Ribble Valley Borough Council
By email

Your ref 3/2026/0222
Our ref DC/26/1129
Date 19-MAY-26

Location: Highcroft Painter Wood Whalley Old Road Billington BB7 9JD
Proposal: Approval of details reserved by condition 2 (specifications of external materials and surface water drainage scheme) of planning permission 3/2024/1022 granted on appeal.

PROPOSED DRAINAGE PLAN

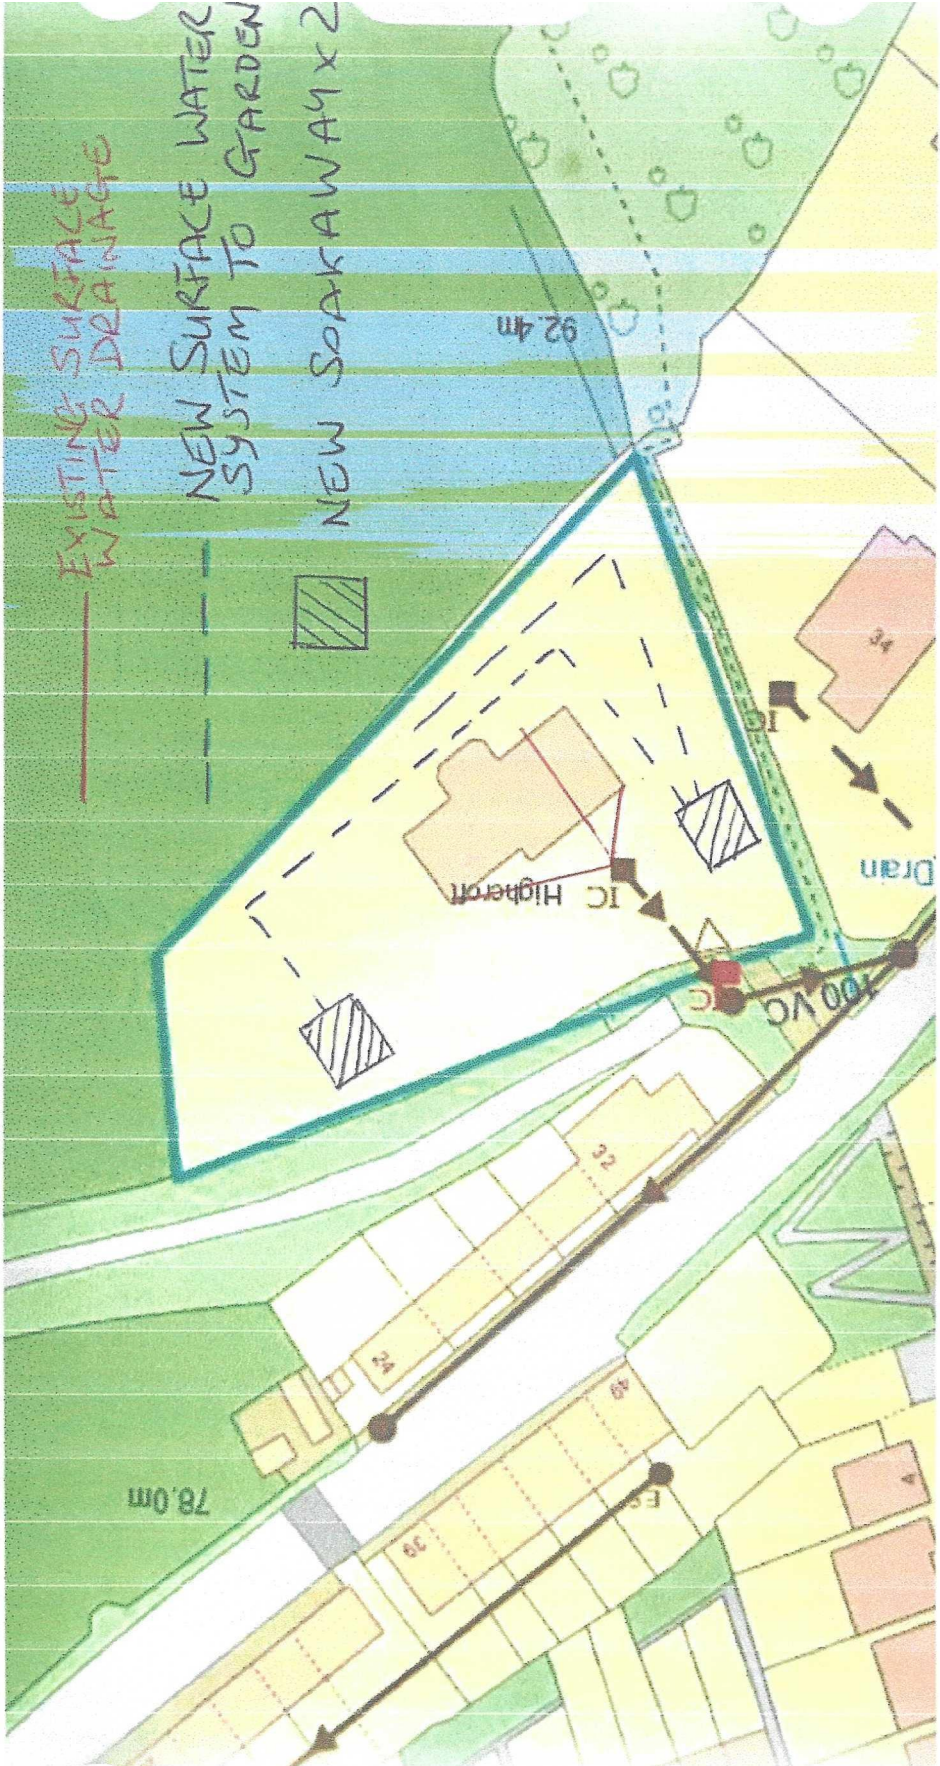
Without details provided of the gabion basket wall and soakaway position, United Utilities cannot comment in detail.

Gabion basket walls, assuming they are retaining will affect the flow of water through the ground as these are considered free draining structures.
